DRB CASE ACTION LOG - BLUE SHEET

Project# 1010649
17DRB-70187 VACATION OF PRIVATE
EASEMENT
17DRB-70188 MINOR - PRELIMINARY/
FINAL PLAT APPROVAL

SURV-TEK INC agent(s) for MILLER FAMILY REAL ESTATE, LLC request(s) the above action(s) for all or a portion of Lot(s) 46-A AND 49-A, Block(s) C, **Unit(s) BOSQUE REDONDO**, zoned C-2, located on VIRGINIA ST NE BETWEEN WYOMING BLVD NE AND TENNESSEE ST

SHEET 3 OF 3

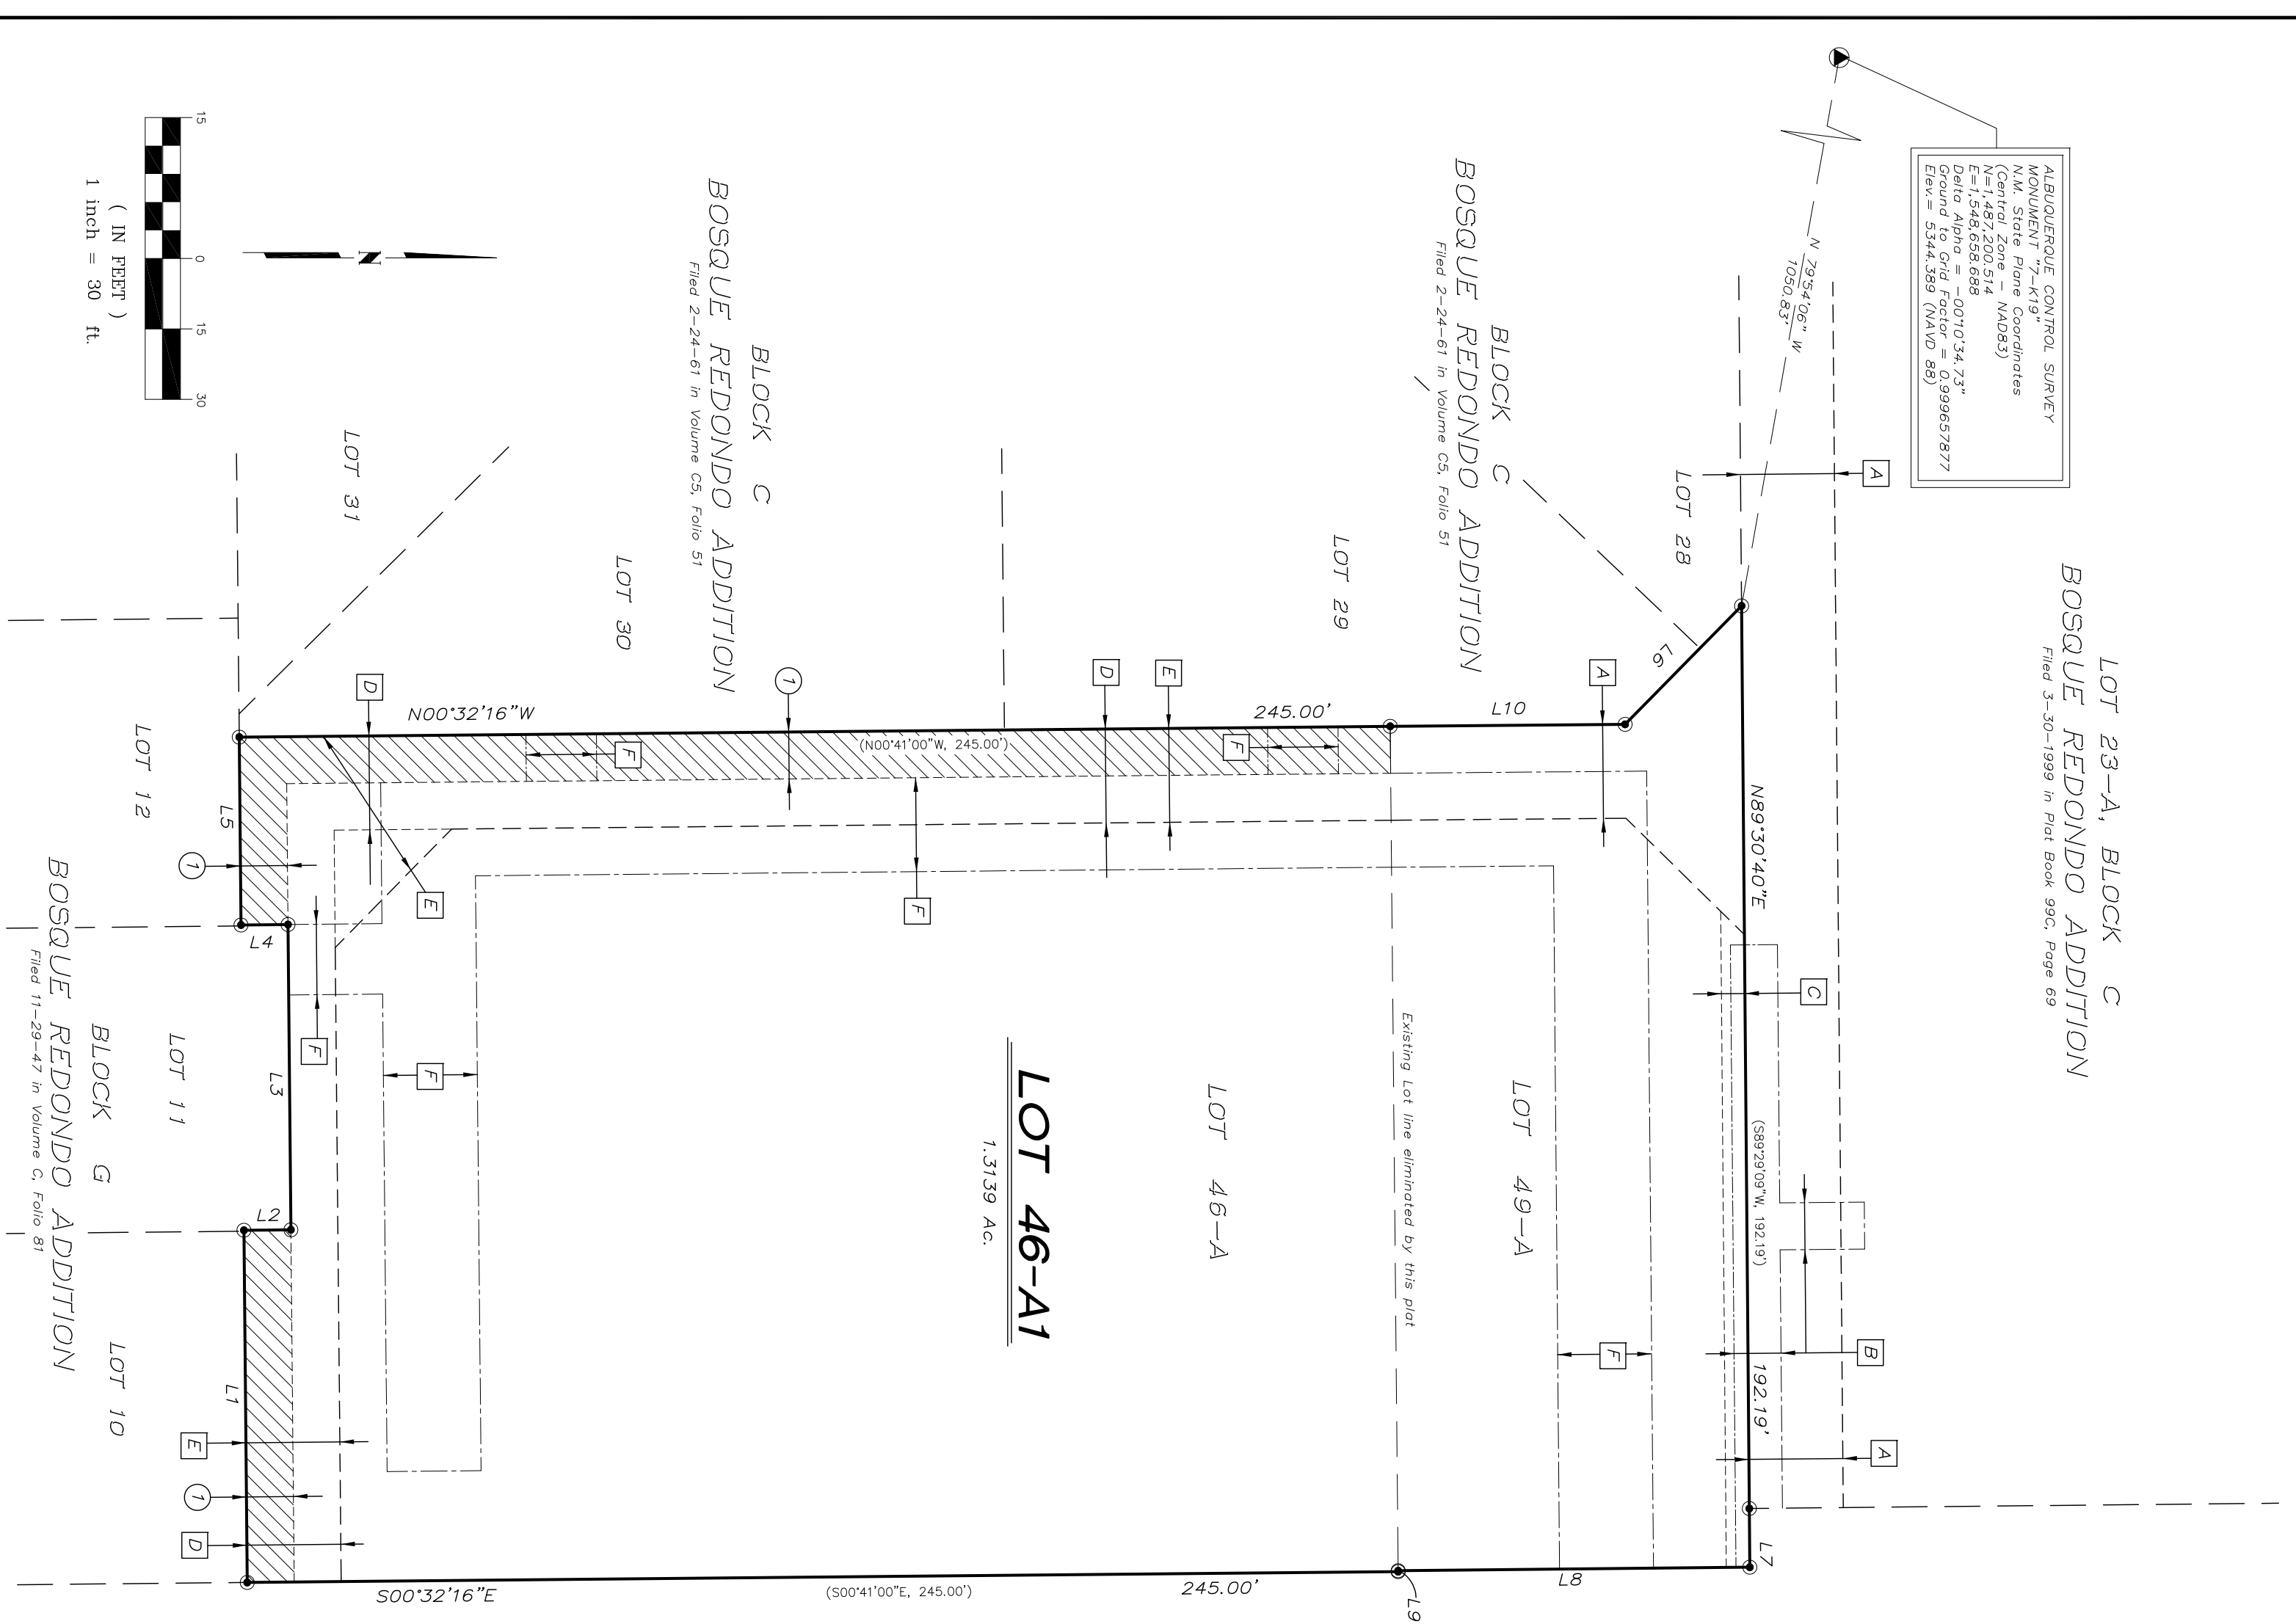
Planning: add Plat plan note
OK
